Our reference: EF14/9902: DOC16/166442
Contact: Michael Heinze 02 6229 7002

25 May 2016

Re: Development Application - Proposed Gunlake Quarry Extension Project, Marulan – SSD15_7090

The EPA has conducted a review of the Environmental Impact Statement (EIS) for the proposal "*Gunlake Quarry Extension Project – Environmental Impact Statement*", prepared by EMM Consulting Pty Ltd and dated April 2016. The EPA has identified a number of issues in relation to the proposal for the Department of Planning and Environment's consideration. Attachment 1 to this letter outlines the specific details in relation to these issues and the EPA's recommendations are highlighted in italics. In summary, the issues relate to:

Quarry noise assessment locations

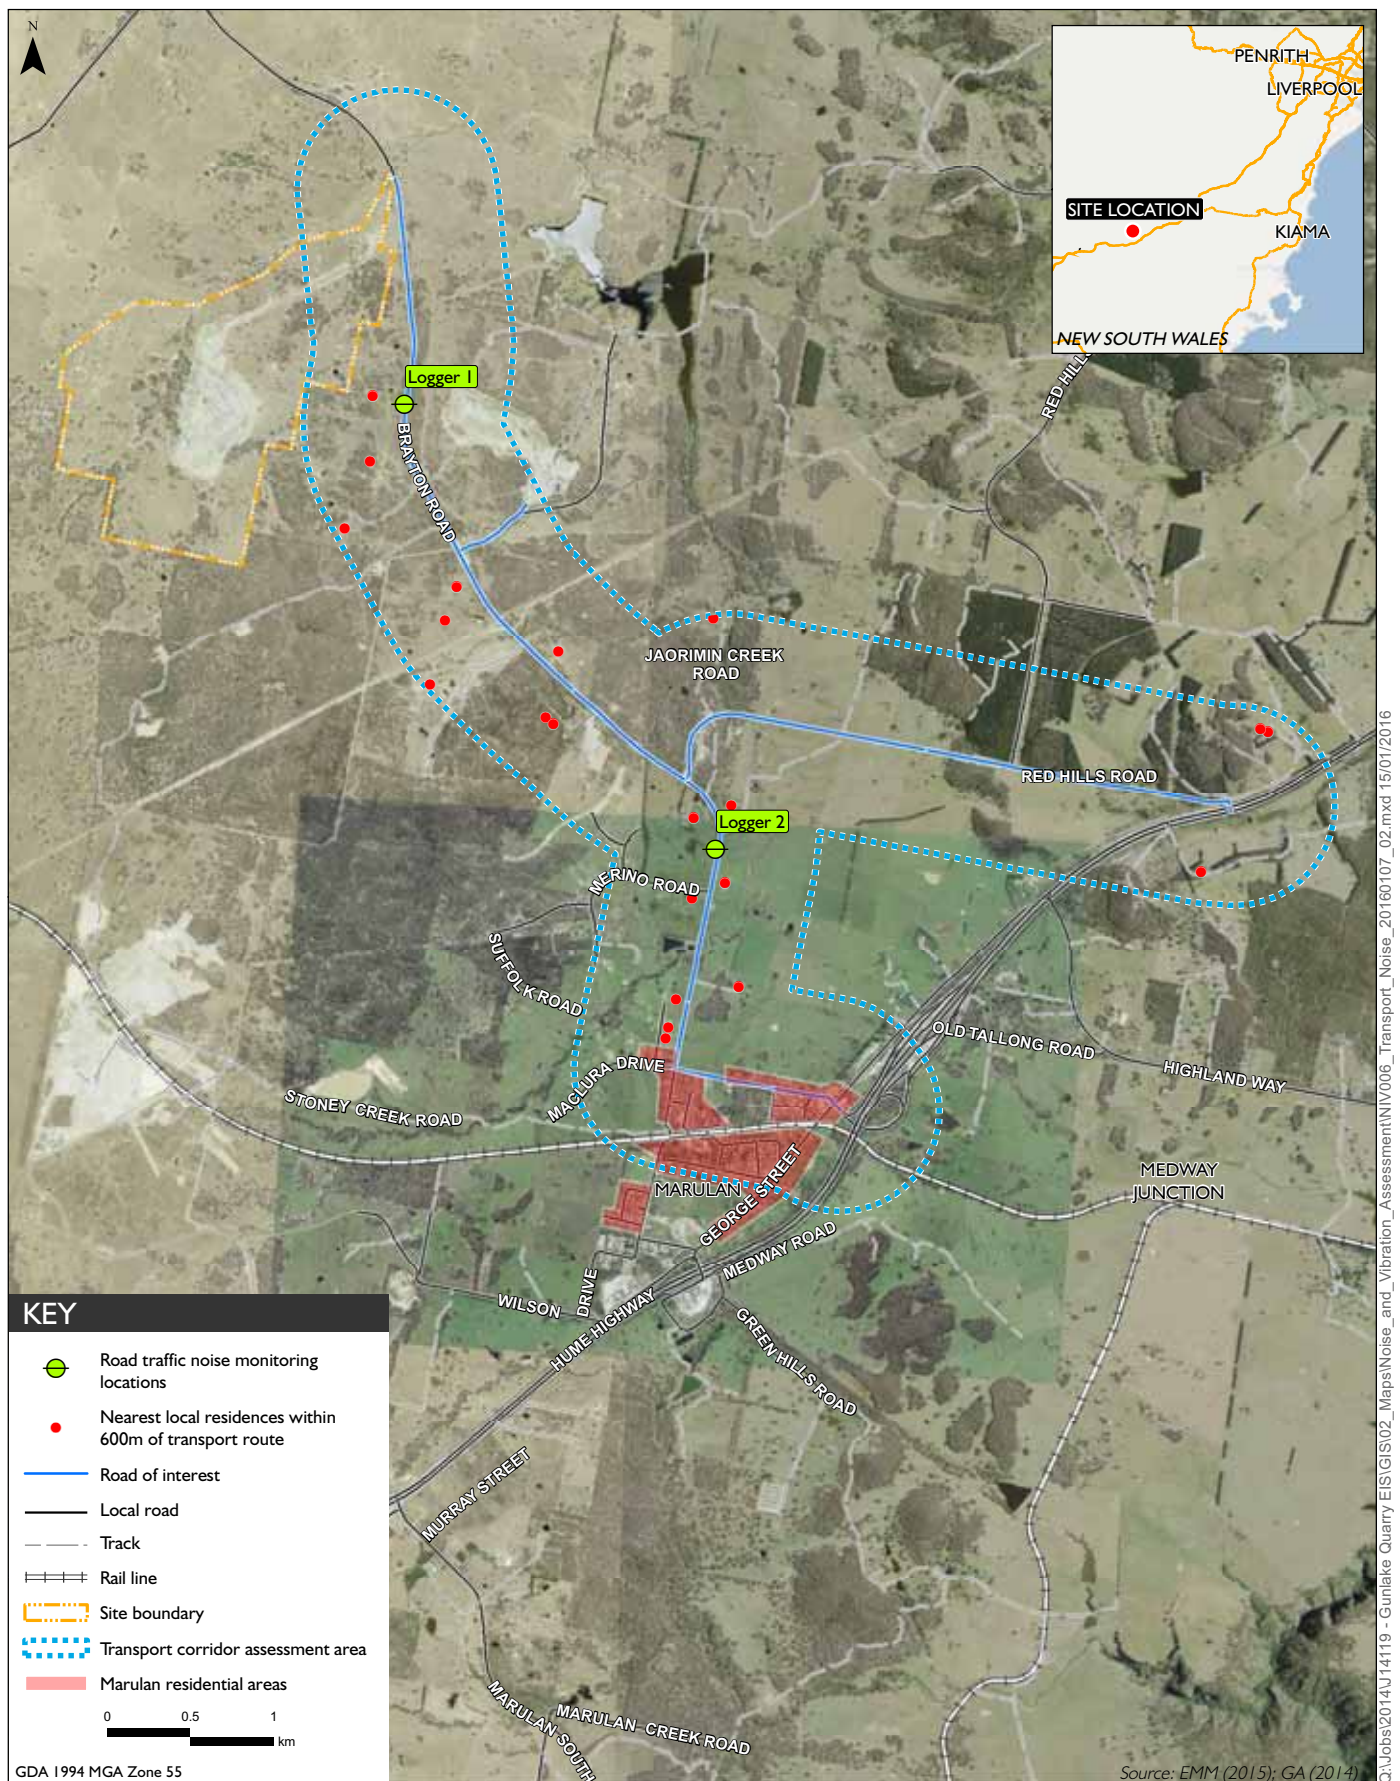
Based on the NVA, the EPA recommends that any approval for this proposal includes the existing noise limits for the Gunlake Quarry project (for receivers R2 and R4) but, as the project will involve the expansion of operations further south and west of the current operations, in addition ***any approval should also incorporate noise limits for the following sensitive receivers:***

Receiver	Location	NOISE LIMITS (dBA)			
		Day	Evening	Night	
		L _{eq} (15min)	L _{eq} (15min)	L _{eq} (15min)	L _{max} (15min)
R5	as noted in NVA	35	35	35	45
R6	as noted in NVA	35	35	35	45
R7	as noted in NVA	38	38	38	45
R8	as noted in NVA	37	37	37	45
